RE: **Texas Roadhouse**
10030 Coors Bypass Blvd NW
Grading and Drainage Plan
Engineers Stamp Date 11/5/15 (B13D014)

Based upon the information provided in your submittal received 11/16/2015, the above referenced Grading and Drainage Plan cannot be approved for Grading Permit or Building Permit until the following comments are addressed.

**SHEET TITLE**  
**GRADING AND DRAINAGE PLAN**

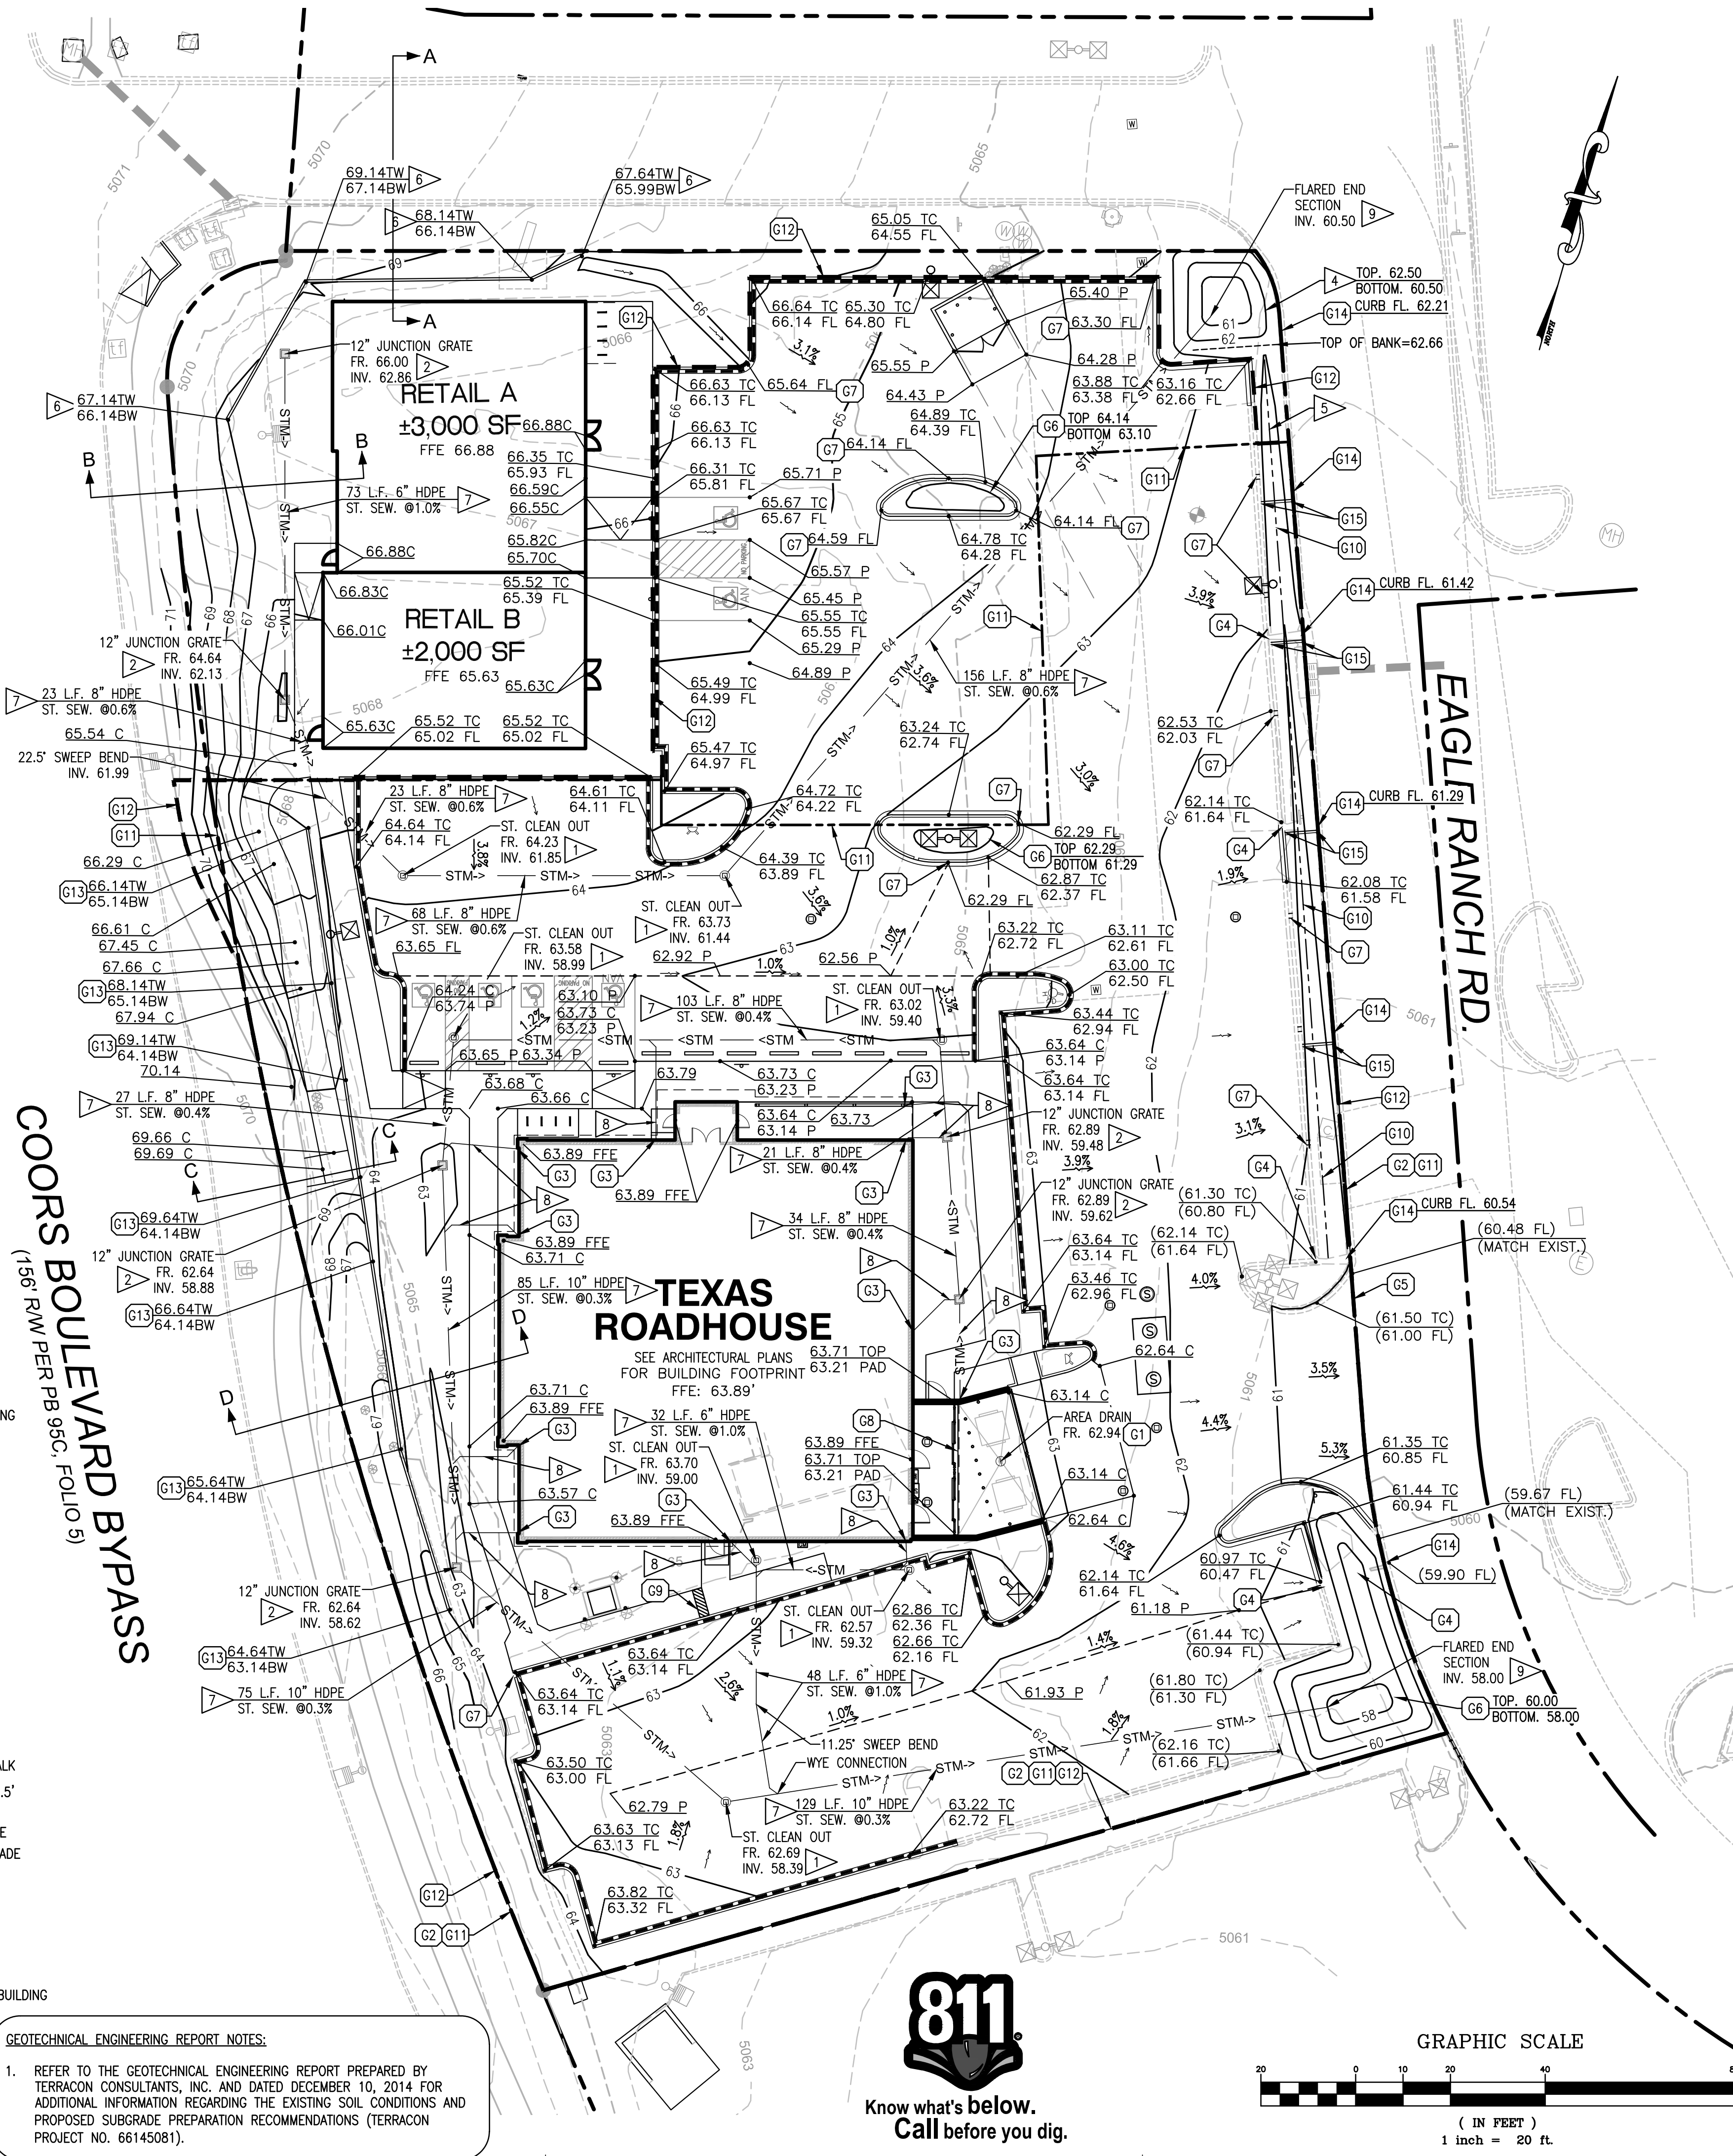
- All flows must run through a pond or swale before running into the storm sewer system. Remove the inlets in the parking areas. Daylight roof drains in the ponding areas. The areas west of the buildings can be graded as ponds with an elevated grate.
- The dumpster area must contain a drain connected to the SAS, with a grease trap.
- The south pond requires an emergency overflow.
- The northeast pond cannot be used for first flush volume if the bioswales bottom is set 18" below existing flowline (which would set the outfall for the pond at the pond's bottom).
- The elevation difference along the bioswale will make it difficult to contain 625cf of volume unless cutoff walls/terracing is called out.
- Pond volumes shown on sheet C4.2 do not match those displayed on sheet C101.
